re: **Response to Geotechnical Comments**
Proposed Residential Development
817 Roseview Avenue, Ottawa
to: Ottawa General Contractors - **Mr. Fares Elsabbagh** -
fares@ottawageneralcontractors.com
date: April 27, 2022
file: PG5852-MEMO.1

Further to your request, Paterson Group (Paterson) prepared the following memorandum to provide responses to review comments regarding the residential development to be located at the aforementioned site. The present memorandum should be read in conjunction with Paterson Group Report PG5852-1 dated October 15, 2021.

PROJECT: 817 ROSEVIEW AVENUE RENTAL BUILDING - 24 UNITS
DRAWING NAME: SITE PLAN
DRAWN BY: --- SHEET: A1
DATE: FEB. 10, 2021
SCALE: AS NOTED #18620

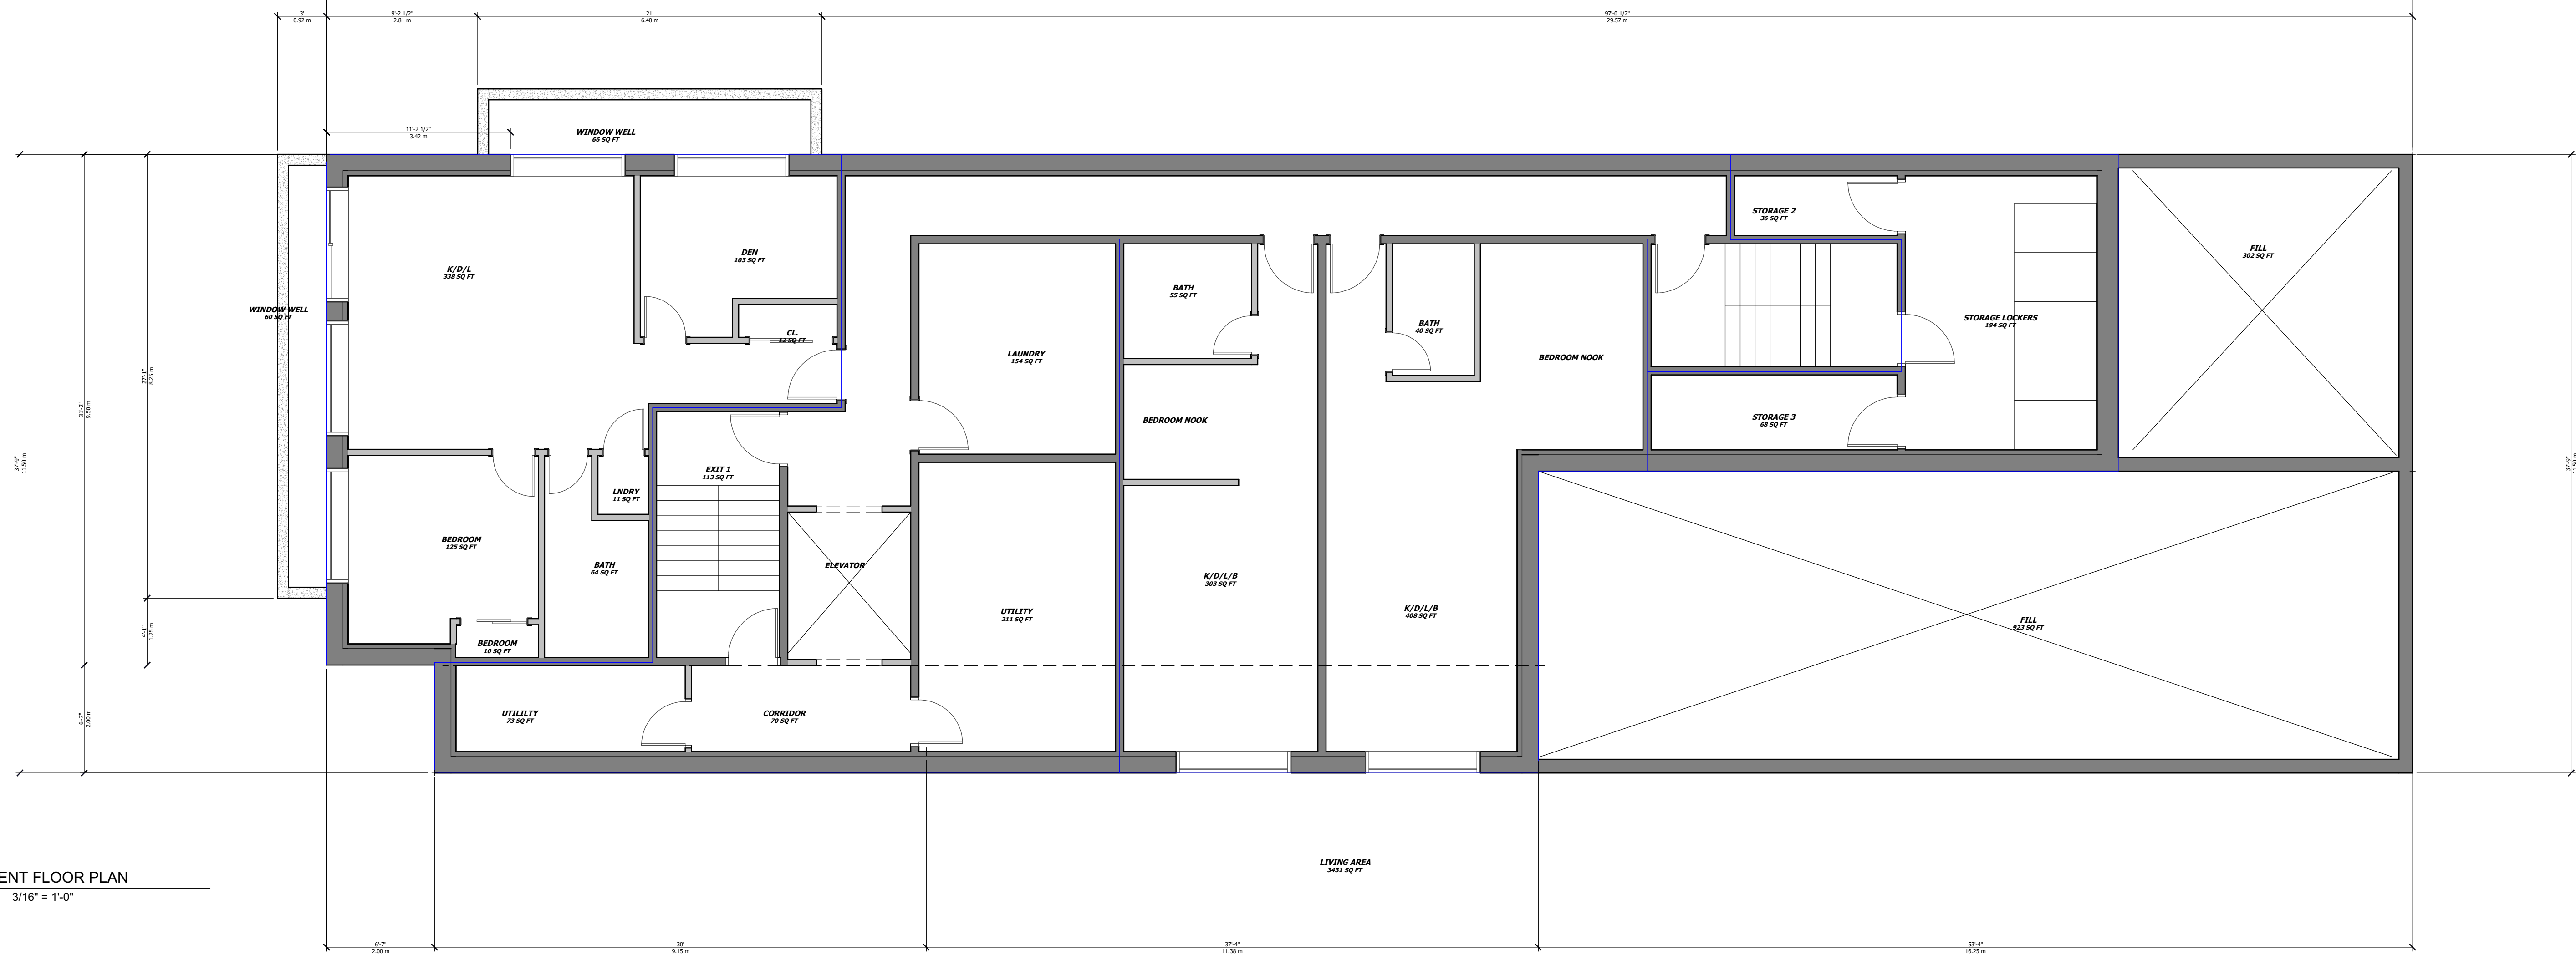
Comment 1: *Please provide a memo confirming that the drawings submitted are in conformance with the recommendations provided in this report.*

Response: Based on our review, the proposed grading is acceptable from a geotechnical perspective. Based on the proposed underside of footing elevation and the required excavation depth, it is anticipated that insufficient room will be available for open-cut excavation methods along the north-west side of the proposed building where only 1.22 m separation is provided between the proposed building and the property line. Recommendations for temporary shoring have been provided in the aforementioned Report. In conclusion, the aforementioned drawings are considered to be in conformance with the recommendations provided in the aforementioned Geotechnical Investigation Report.
